Letter No. A1/24211/2004

Sub: CMDA -Planning Permission - Construction of Ground Floor + First Floor with two dwelling units Residential Building at Plot No.23, Ayyavu Nagar, S.N .201 pt., 201/3 (as per patta) of Maduraveyal village - Development charges and other charges to be remitted - Reg.

Prop Site / Ground Floor Plan

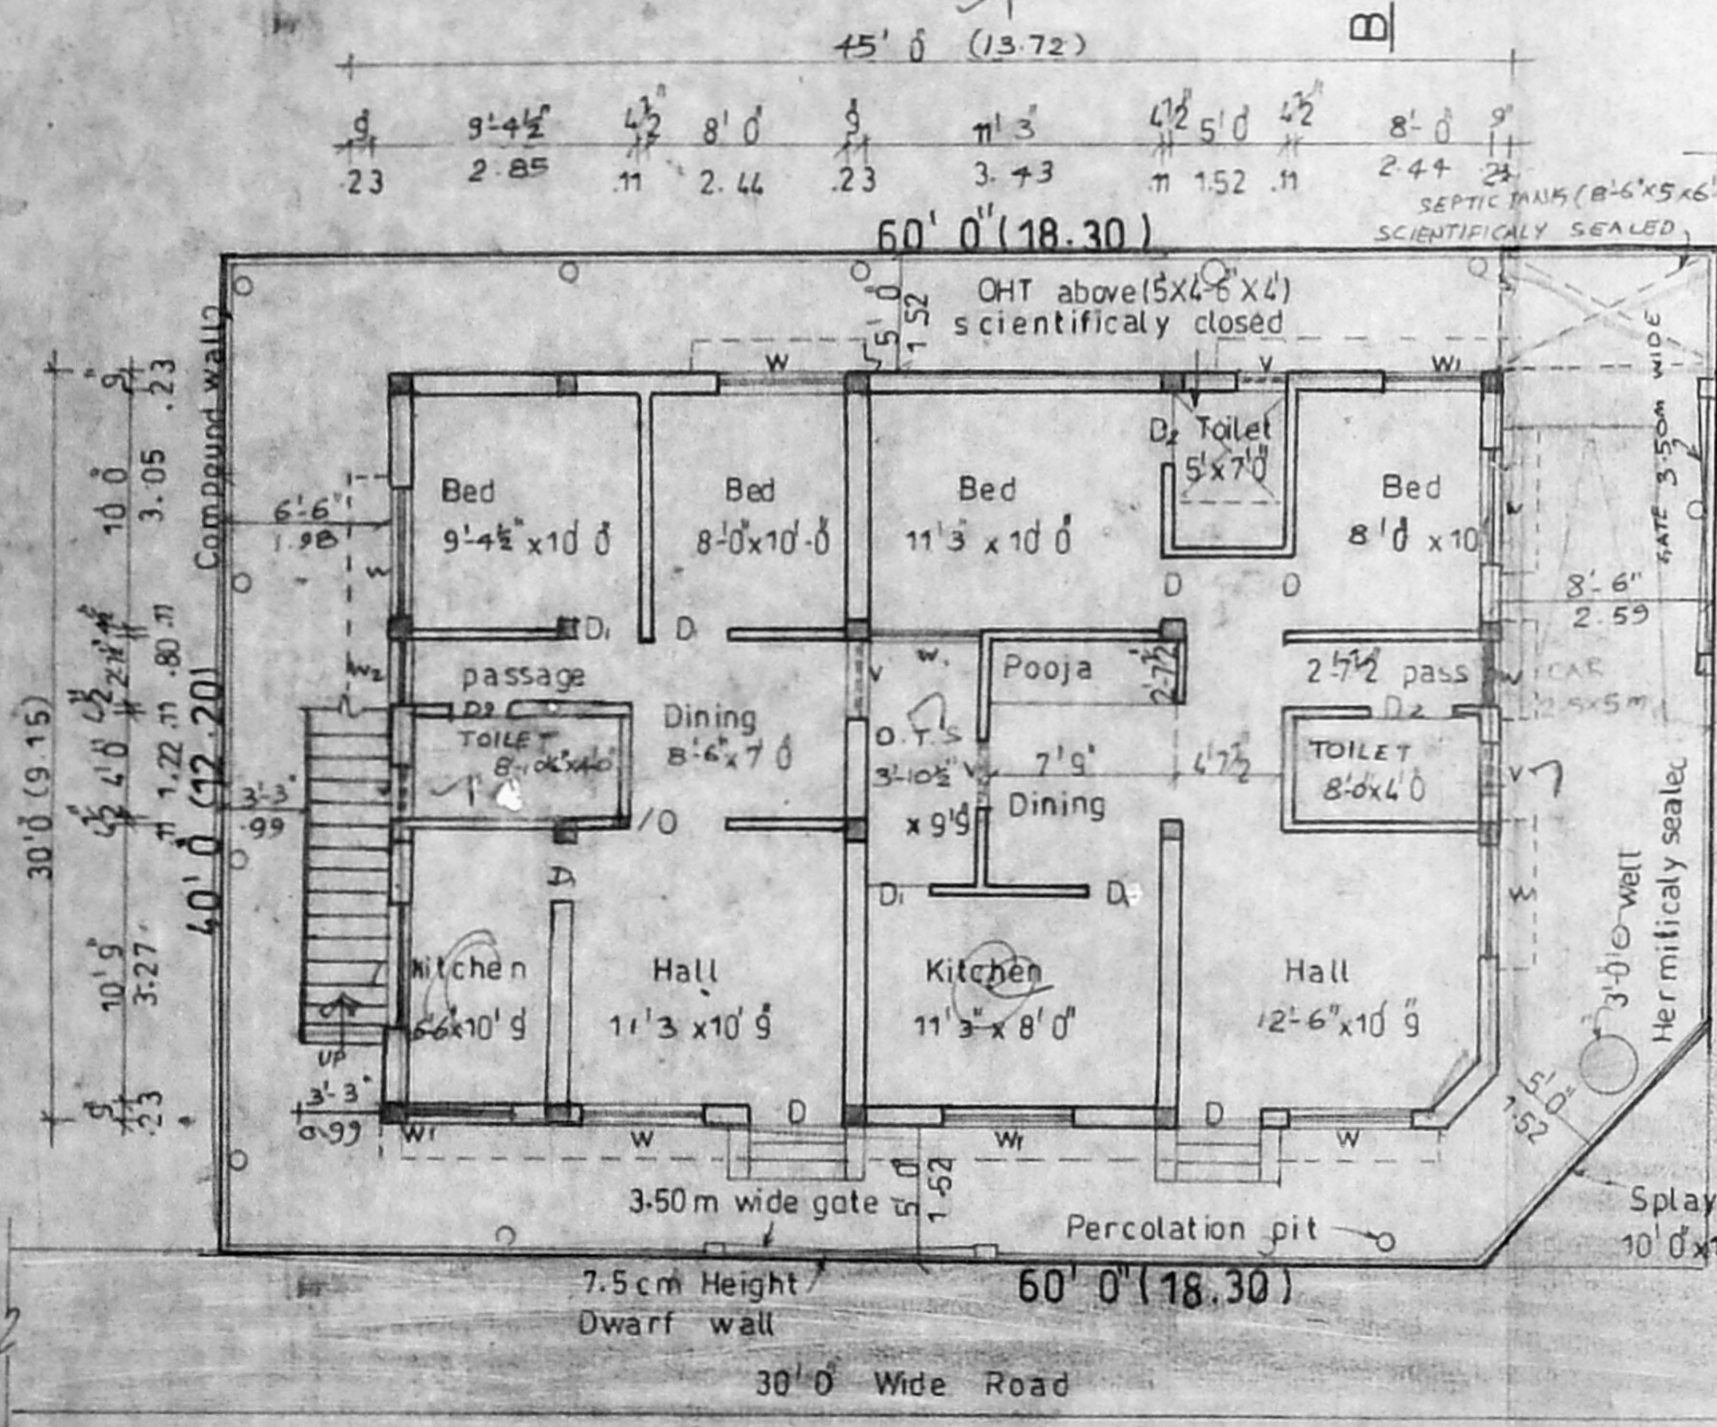
- a) Rain Water conservation Regulations stipulated by CMDA should be adhered to strictly.
- b) 5 copies of revised plan showing
  - i) S.No. as per pattah i.e. 201/3 to be indicated in the main title of plan.
  - ii) 'Duct' at GF to be renamed as OTS and same to be indicated at Terrace plan also.
  - iii) Septic tank details to be shown in the location of the site plan.
  - iv) Ventilation to Bath at Ground Floor to be shown.
